Please ask for: Mrs D Johnson
Email: daun.johnson@arun.gov.uk
Telephone: 01903 737762
Our Ref: Y/2/21/L
Your Ref: Mr Barron
Date: 13th January 2021

Listed Building Consent for Alterations, Extension or Demolition of a Listed Building

Development: Listed building consent for the removal & replacement of a rear door.
Location: The Twelfth Of Never Church Lane Yapton BN18 0EH

Figure 1 – Aerial photo showing location of rear door and property location plan

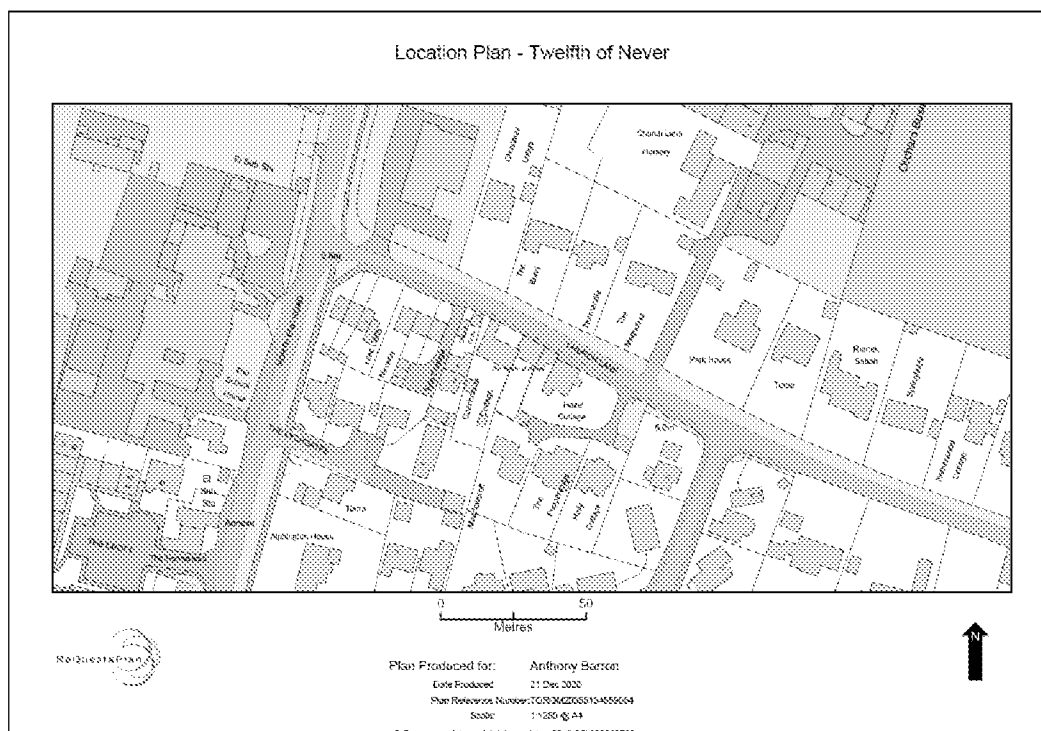
Block Plan

Please clearly show the position of the door that is being replaced.
